**MODIFICATION REQUEST:
Residential and Child Care Centre
Development
14-18 Boondah Road Warriewood
MP10_0177 MOD 12**

Director-General's
Environmental Assessment Report
Section 75W of the
Environmental Planning and Assessment Act 1979

November 2012

THIRD FLOOR
SCALE 1:200

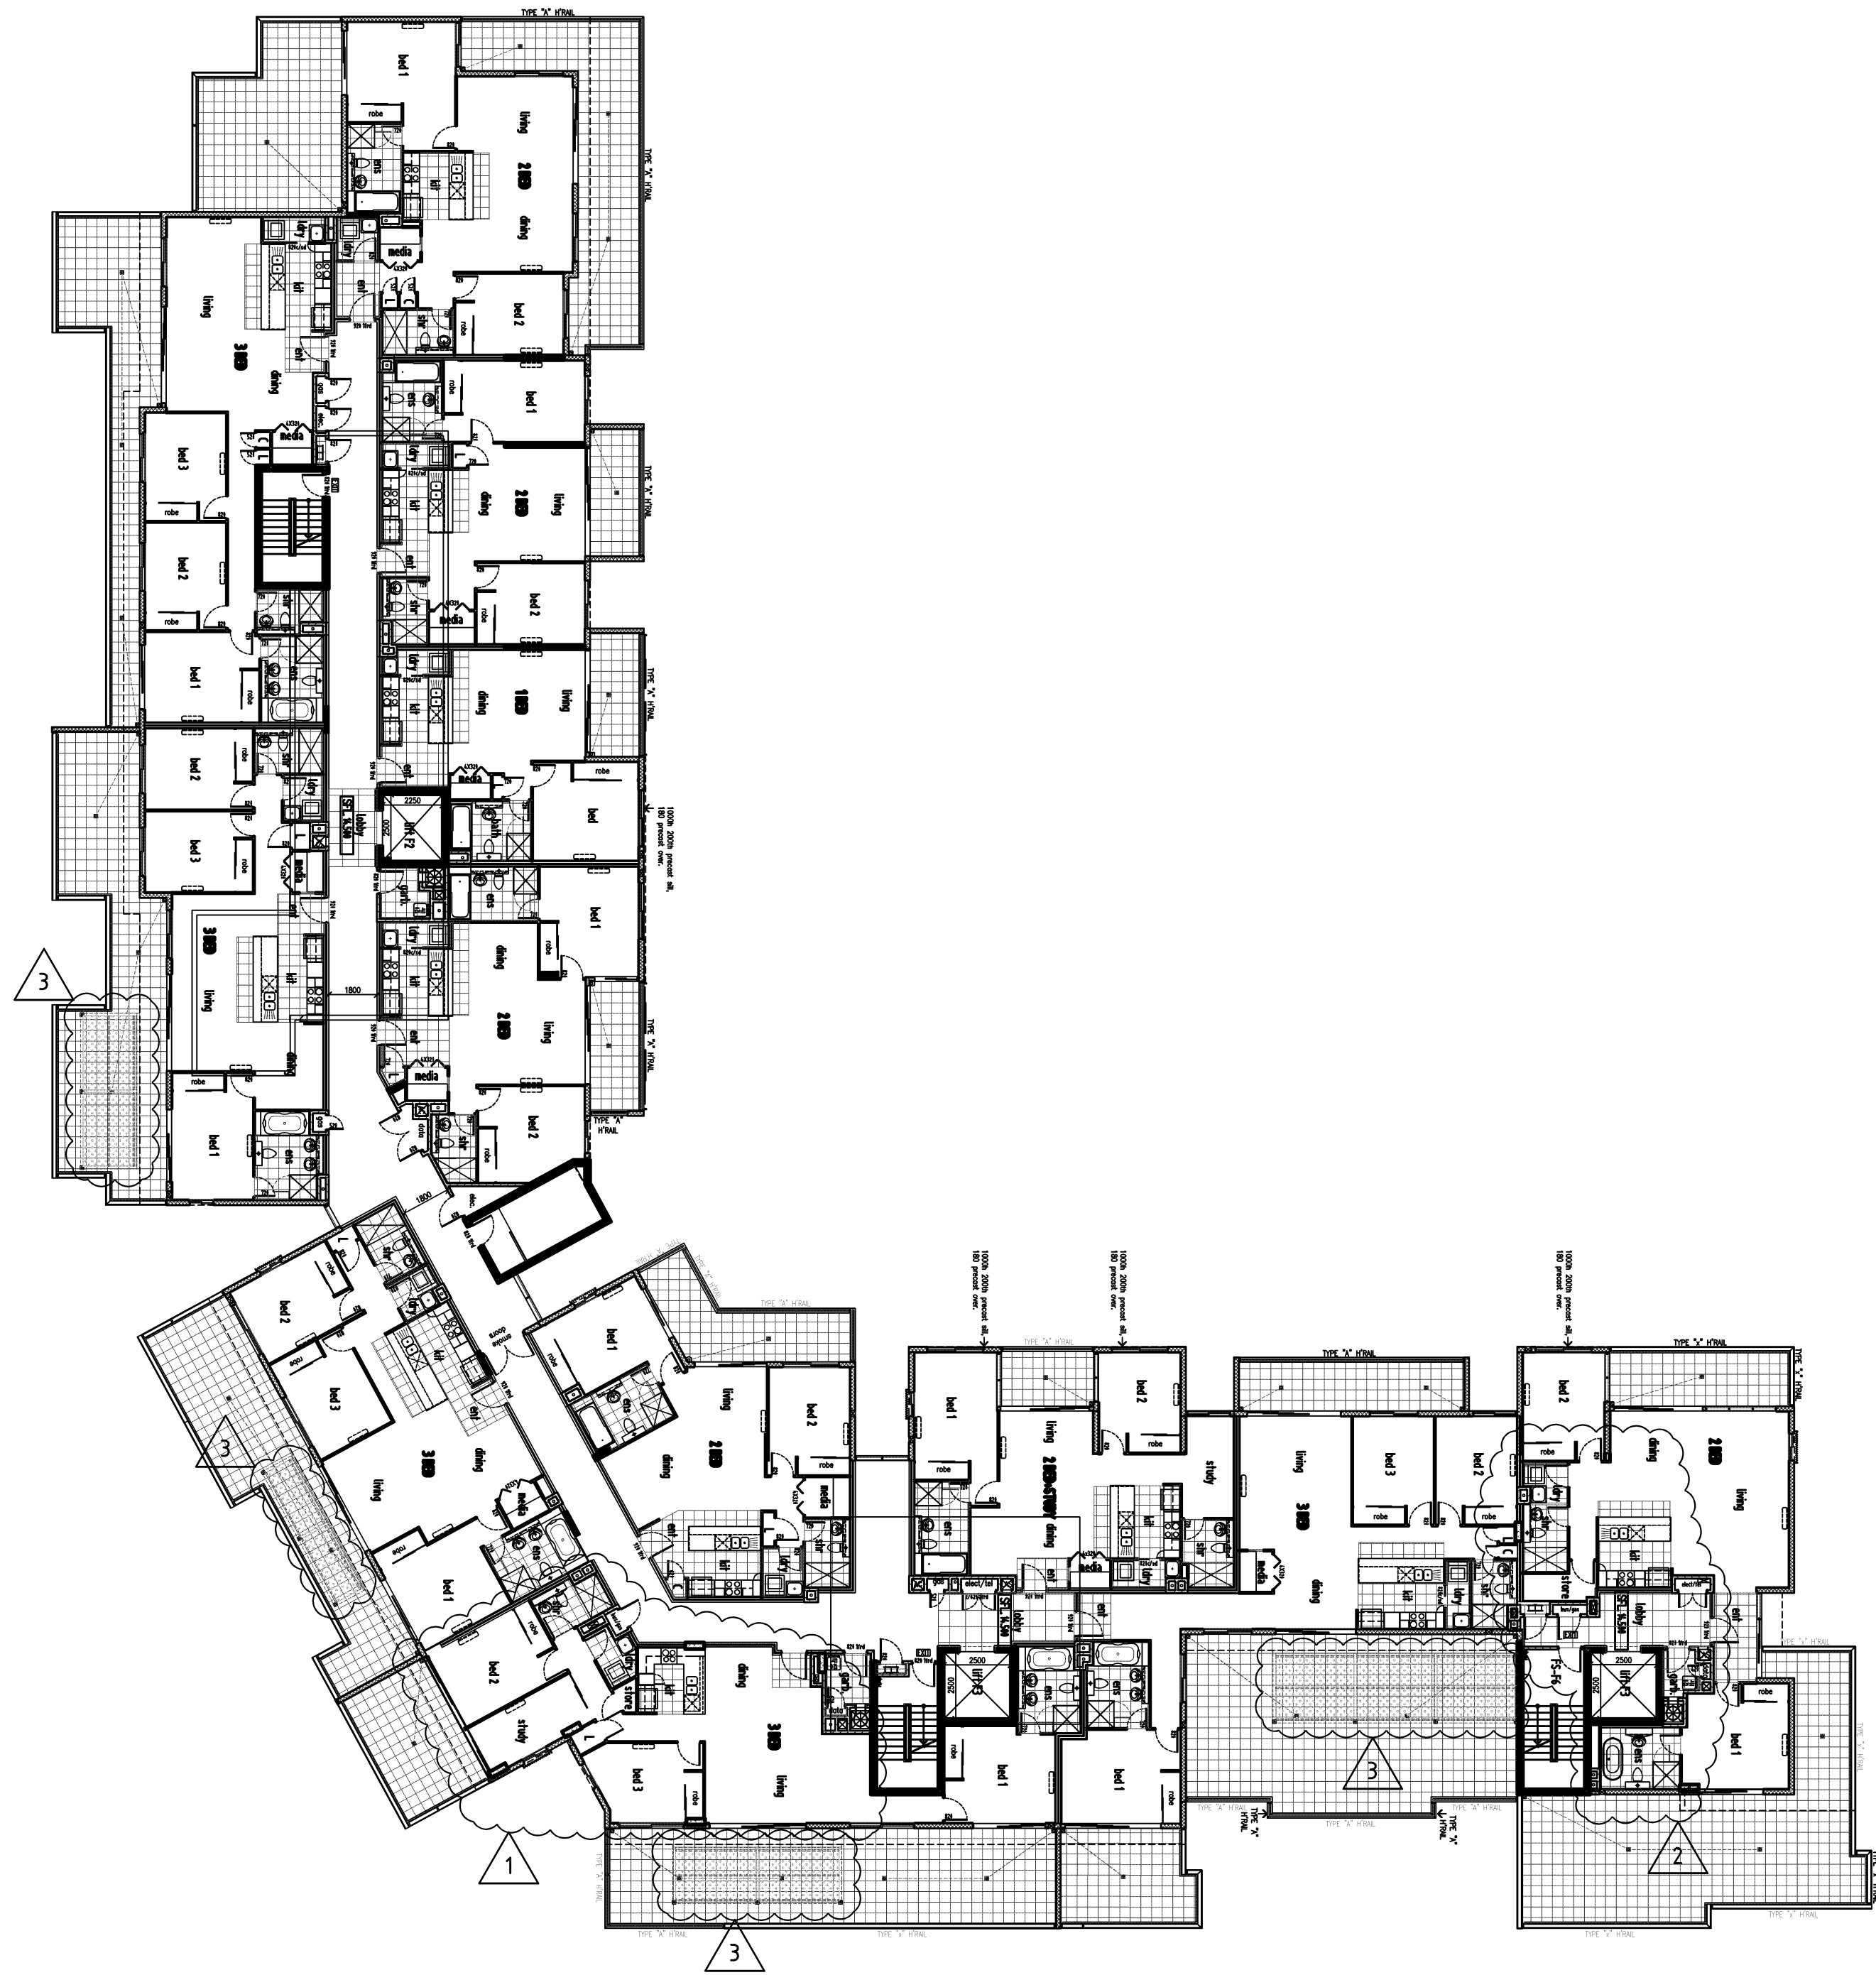
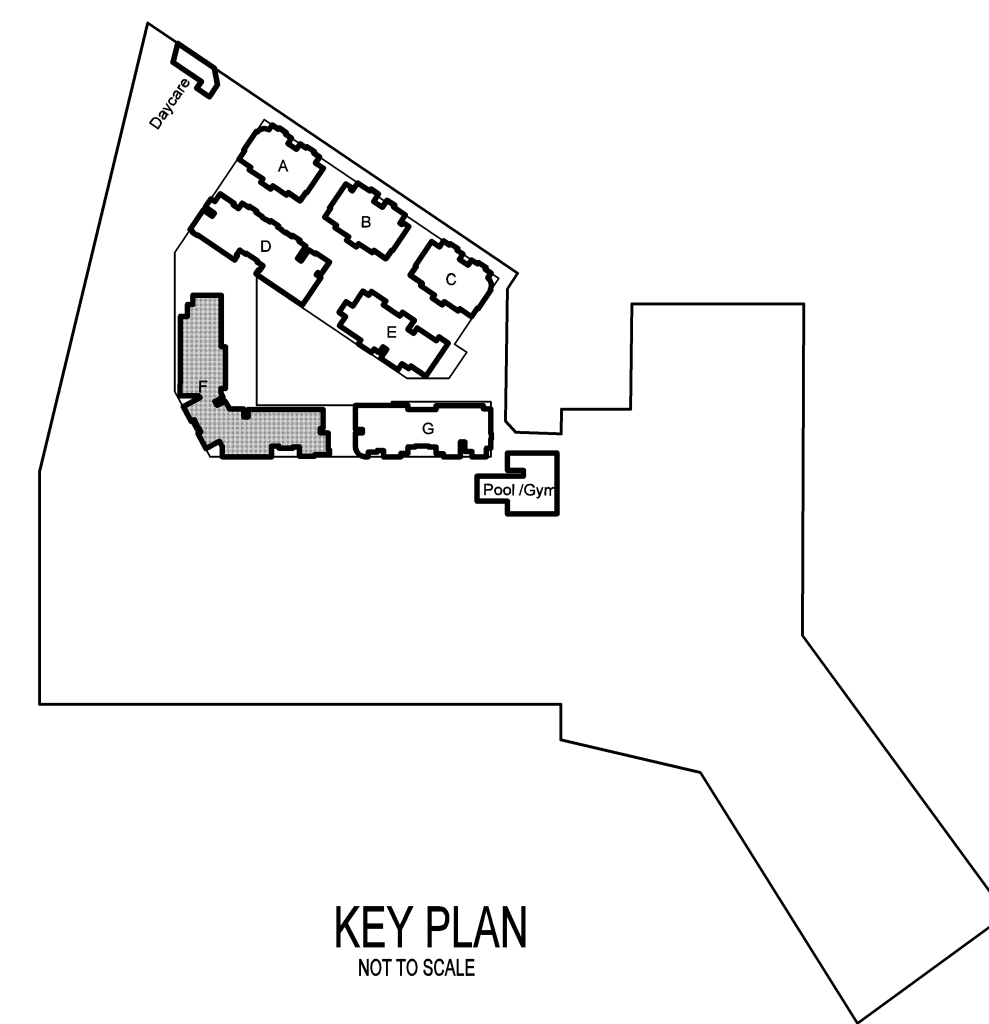
The determination of the original development required that car park spaces are to be provided in accordance Council's DCP requirements, which identifies specific rates based on the number of bedrooms contained in a unit. The internal layout of Unit 349 is modified under this application by the addition of a study. The proposed study occupies a portion of an approved bedroom, which is depicted in **Figure 5** below.

In comparing a portion of the approved and proposed floor plans of Building F, the size of the proposed study is considered to be sufficiently constrained making it undesirable for use as a bedroom. Furthermore, even if an additional bedroom was added to Unit 349, resulting in a total of 4 bedrooms, no change to the required number of car park spaces would result as no rate exists for units containing over 3 bedrooms under Council's DCP or the RMS guidelines.

FLOOR PLAN
POOL and GYM

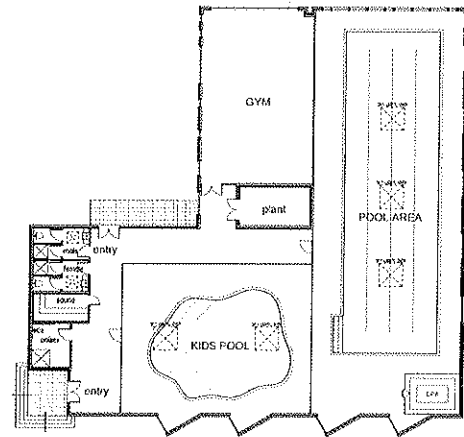
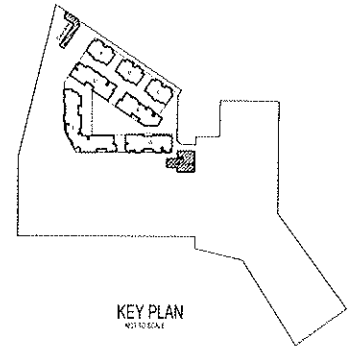
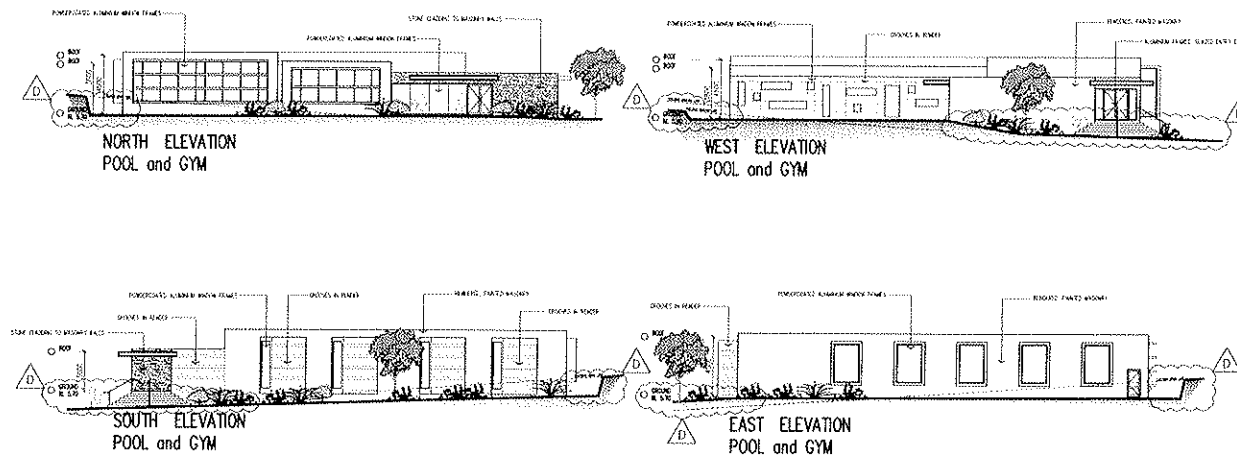
Figure 4: Proposed modification to height of Pool Building windows

By comparing the approved and proposed elevations in **Figures 2, 3 and 4**, it is apparent that the increase in the bulk and scale of the buildings is negligible and that no significant change is proposed to the design aesthetic of the buildings from the current approval. The proposal is therefore considered acceptable in this regard.

The internal design modifications proposed to Building F and the Pool Building are considered minor in scale and would maintain an acceptable level of internal amenity in accordance with the provisions of the RFDC.
